RE: Transmittal of Comments – Mitchell Short Plat (SP-17-00003)

TO: All Staff
FROM: Justin Turnbull, County Surveyor 
DATE: January 23, 2018
SUBJECT: County Survey Review of Short Plat 17-00003 (Naneum Rd)
(CDS refers to this as 17-00003 Mitchell)

TO: Community Development Services
FROM: Kelly Bacon, Engineer Technician I *KB*
DATE: January 23, 2018
SUBJECT: Mitchell Short Plat SP-17-00003 *B*

RE: WDFW comments on SP-17-00003 Mitchell Short Plat along the Ferguson Branch of Naneum Creek

NANEUM ROAD SHORT PLAT
PART OF SECTION 33, T. 18 N., R. 19 E., W.M.
KITITAS COUNTY, WASHINGTON

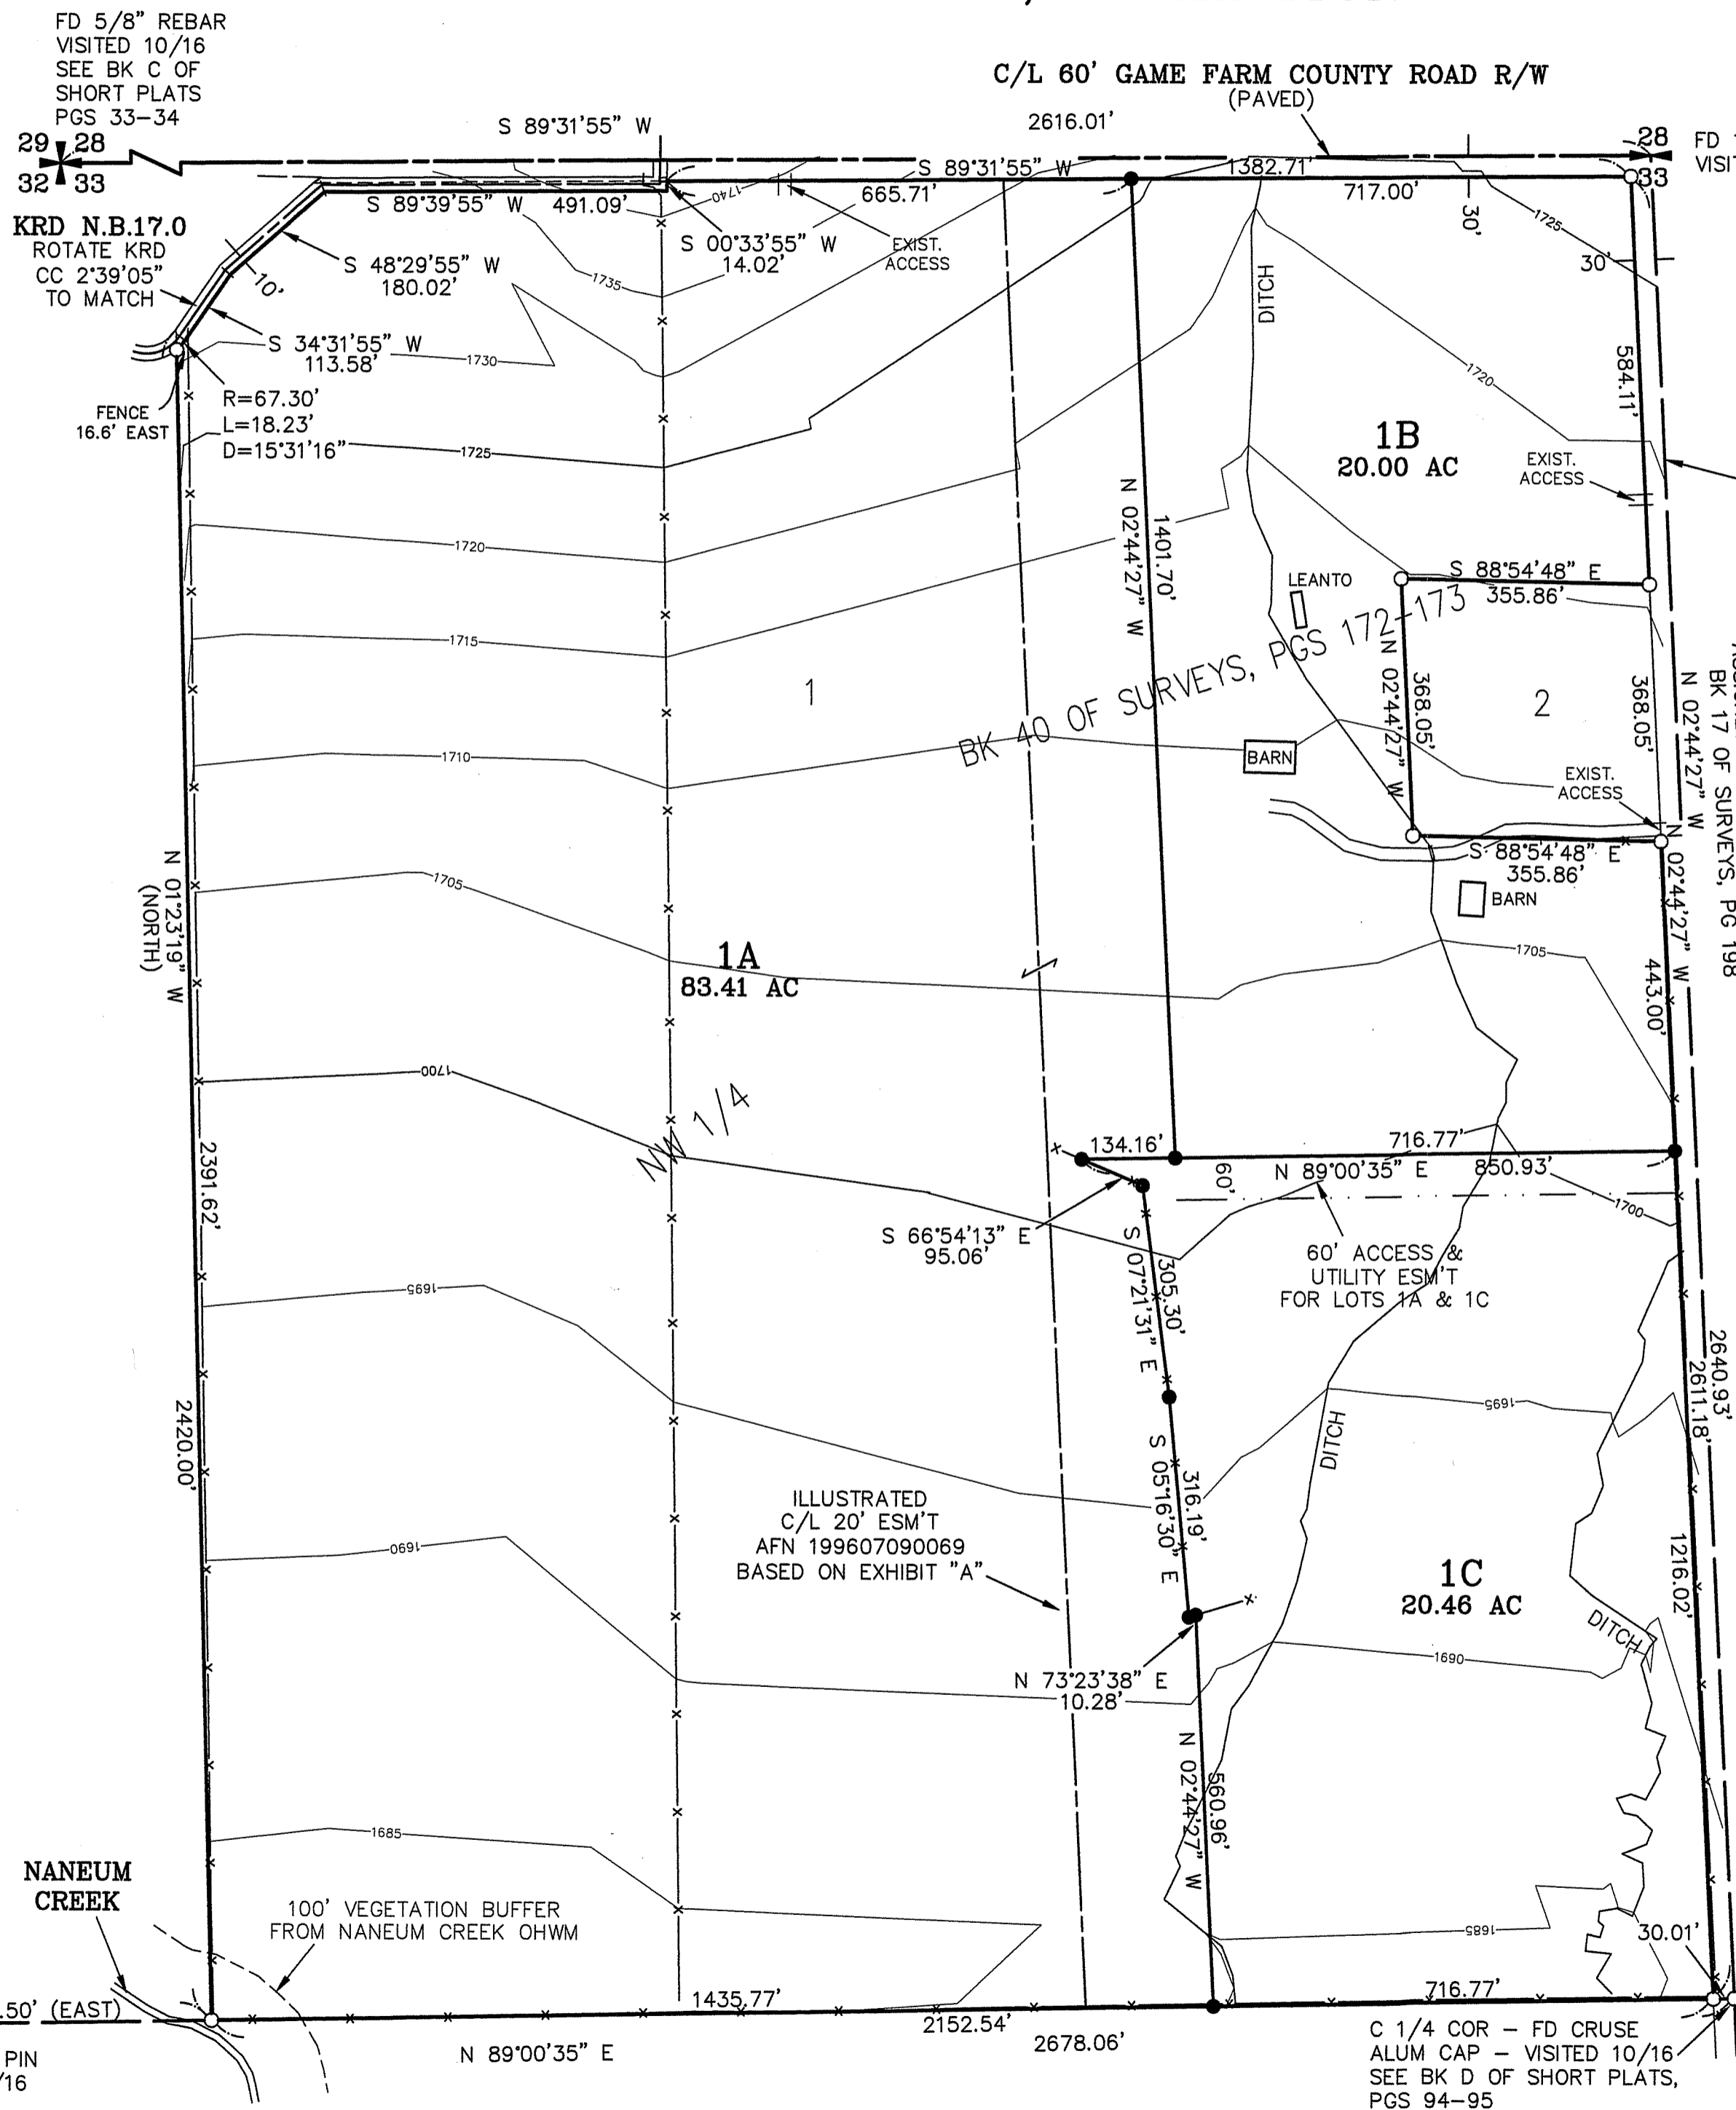
1. No Lot closures provided as part of the submittal, please provide prior to final approval.
2. No Title report included as part of the submittal, please provide prior to final approval.
3. Where elevations or contours are shown, a note stating the vertical datum used is required. If the elevations are assumed, a benchmark (or solid unmistakable feature), with elevation shown shall be noted on the face of the map.

1. Access to Lot 1B: A 30' Joint Access easement for lot 1B and tax parcel 30936 to be shown on the face of the short plat.
2. Driveways: A driveway shall serve no more than two tax parcels. See Kittitas County Road Standards, 12/15/15 edition.

events (see attachment). As currently proposed, parcels 1B and especially 1C look to have extremely limited future buildable areas if proper critical area protections are applied for 1) wetlands, 2) geological hazards (alluvial fans, channel migration zones), 3) frequently flooded areas, or 4) fish and wildlife habitat conservation areas (streams, riparian areas).

We believe lot 1C may not have a future building site that will not be at risk of flood damage and that will protect critical area functions associated with the Ferguson Branch. We recommend a reconfiguration of the proposed lots to ensure a non-buildable lot is not created with this process. Please ensure approval of this short plat will provide adequate protection to the Ferguson Branch and the critical areas associated with it into the future.
